TAMWORTH REGIONAL COUNCIL SUBMISSION – STATE SIGNIFICANT DEVELOPMENT – HILLS OF GOLD WIND FARM – APPROXIMATELY 5 KM SOUTH OF HANGING ROCK AND 8 KM SOUTH-EAST OF NUNDLE

Ref: Ir/SL/GV Document Set ID 606951

10 February 2021

LEGEND
REFERENCE ONLY

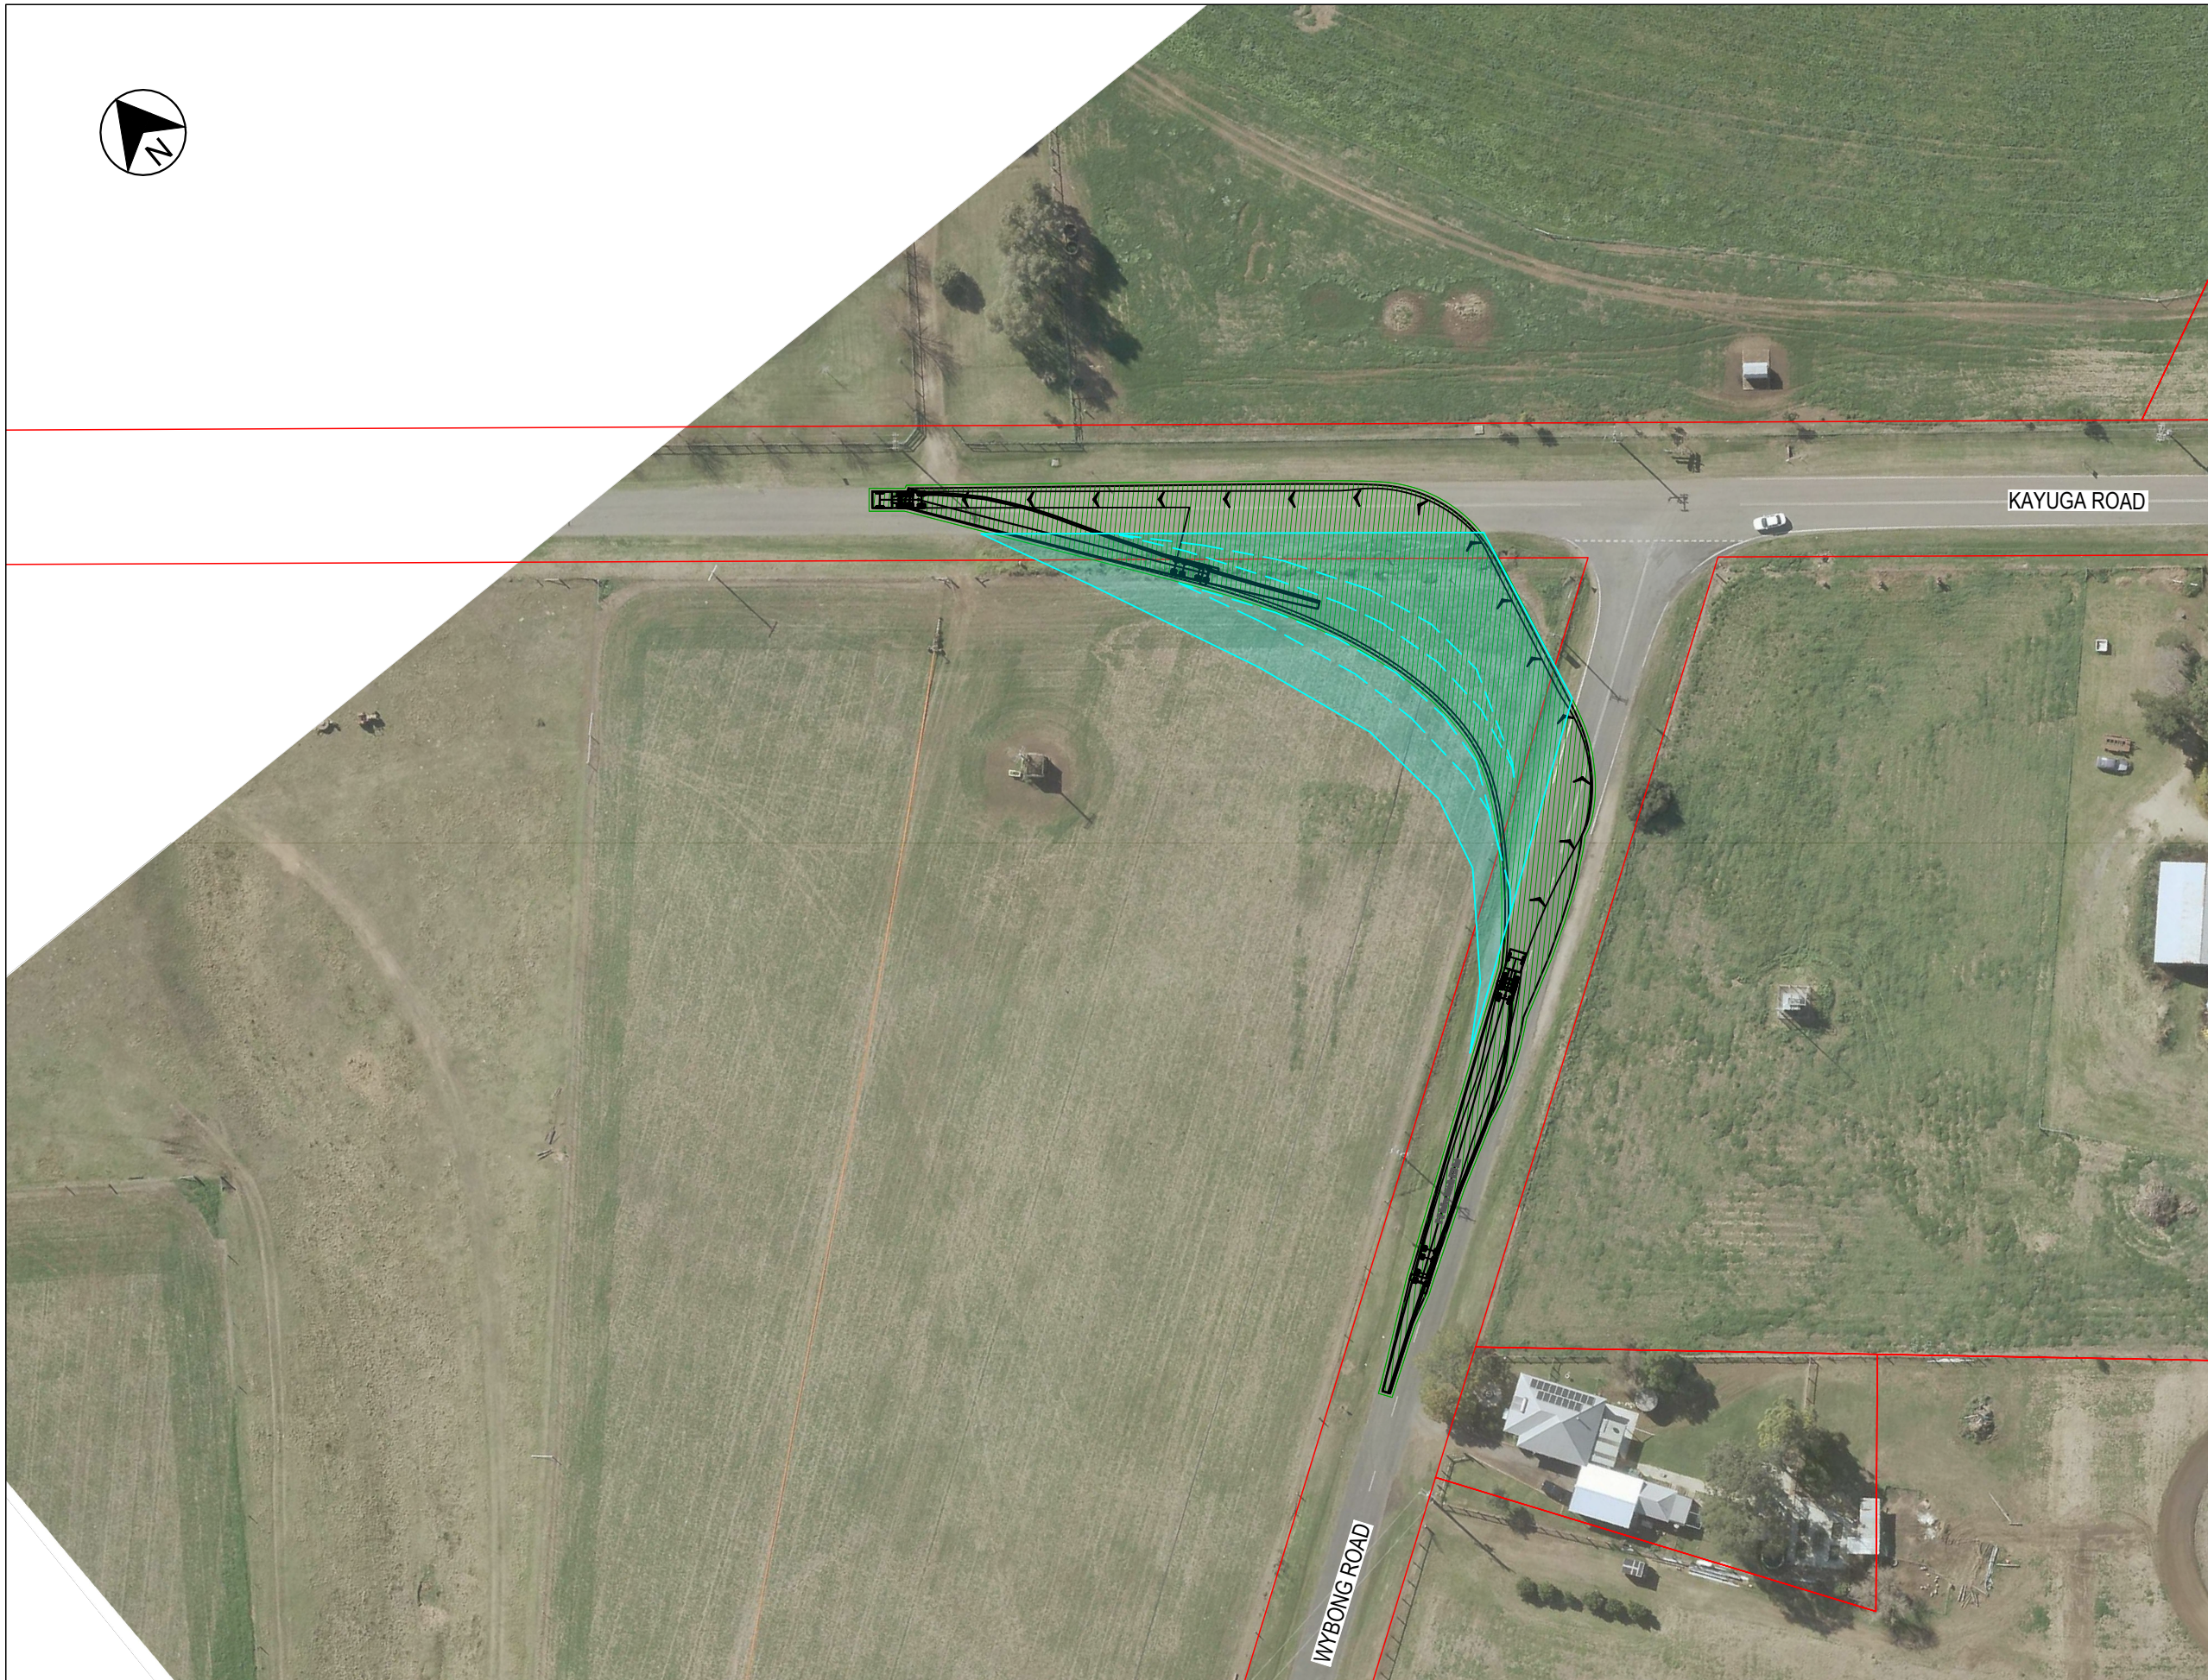
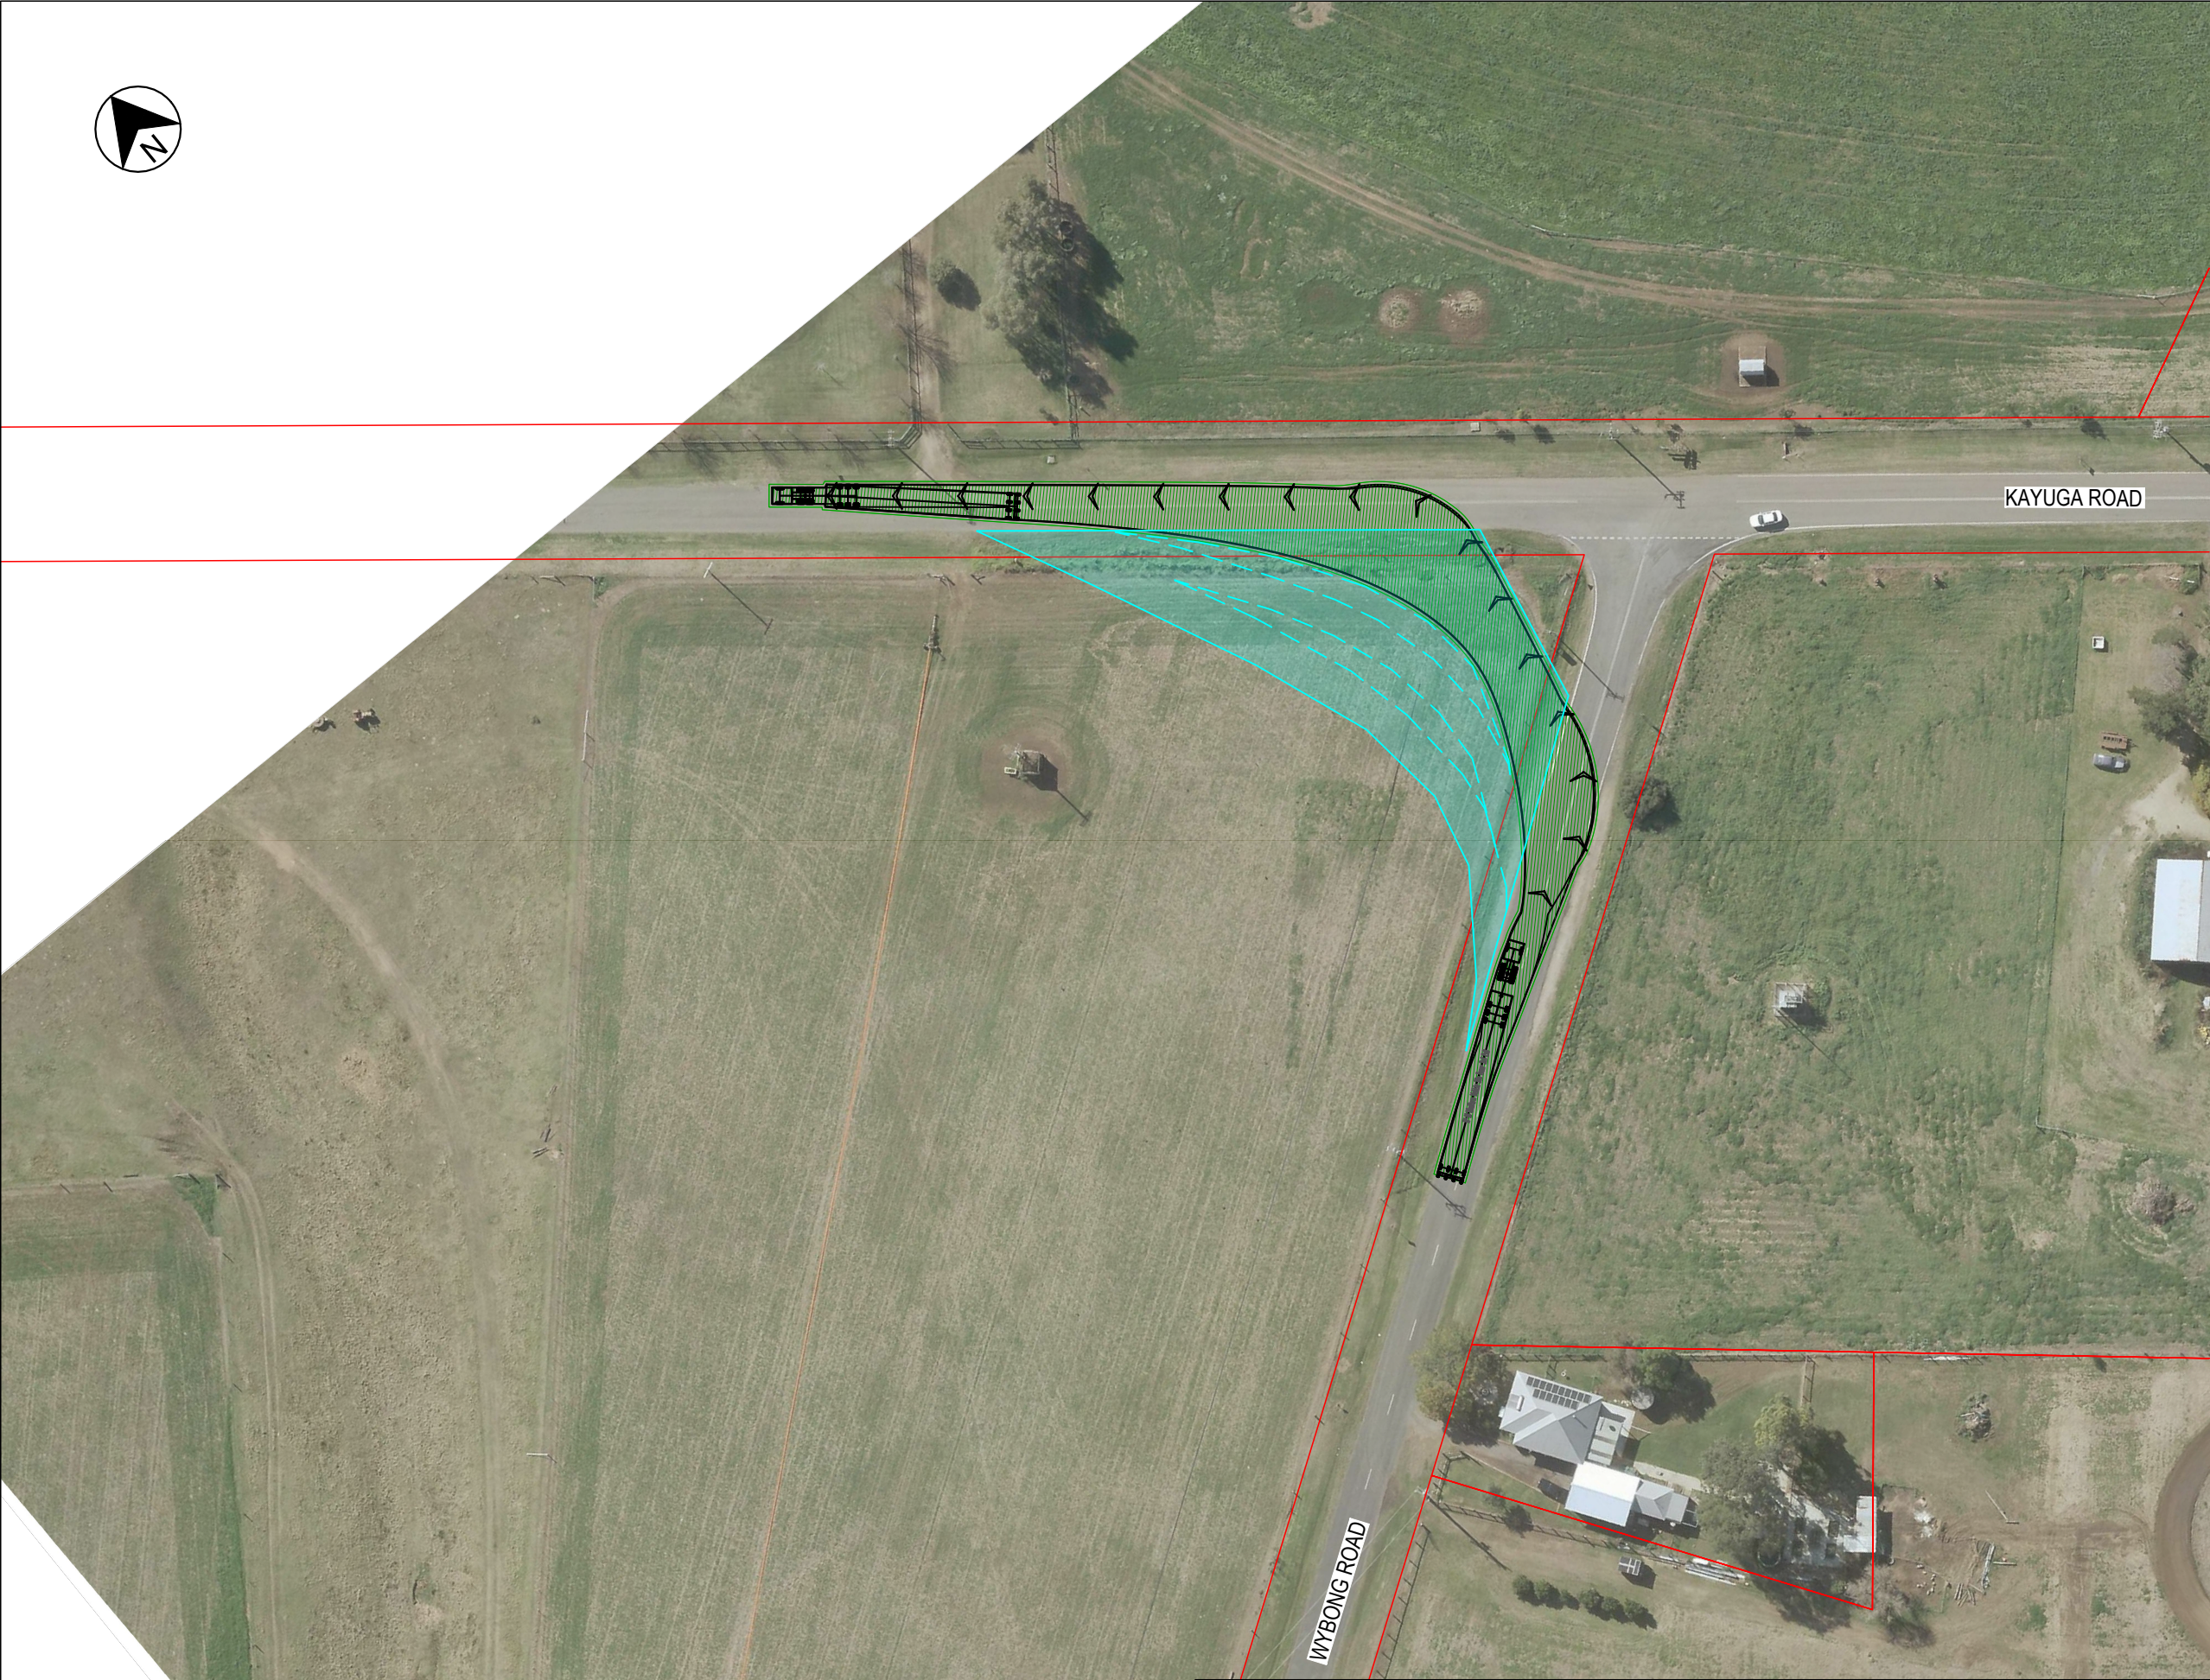
The assessment however appears to be based on *plan-view* geometry and therefore understates the extent of impacted areas where there are *cuttings* and *batters*. The assessment is also confined to identifying the geometric extent of the impact – but does not explore the mechanisms for achieving the extra *clearing*, *infrastructure relocations*, *land acquisitions* and the like.

The intrusions into adjoining landholdings will also need to be resolved with the relevant owners, and an accurate geometric extent will need to be defined in order to facilitate these negotiations.

Whichever route is ultimately selected, road upgrades will be required in order to facilitate the RAV movements. These upgrades will likely include load assessment and resultant augmentation of structures, widening existing narrow bridges and causeways, straightening some of the more extreme horizontal and vertical alignments, and widening certain intersections.
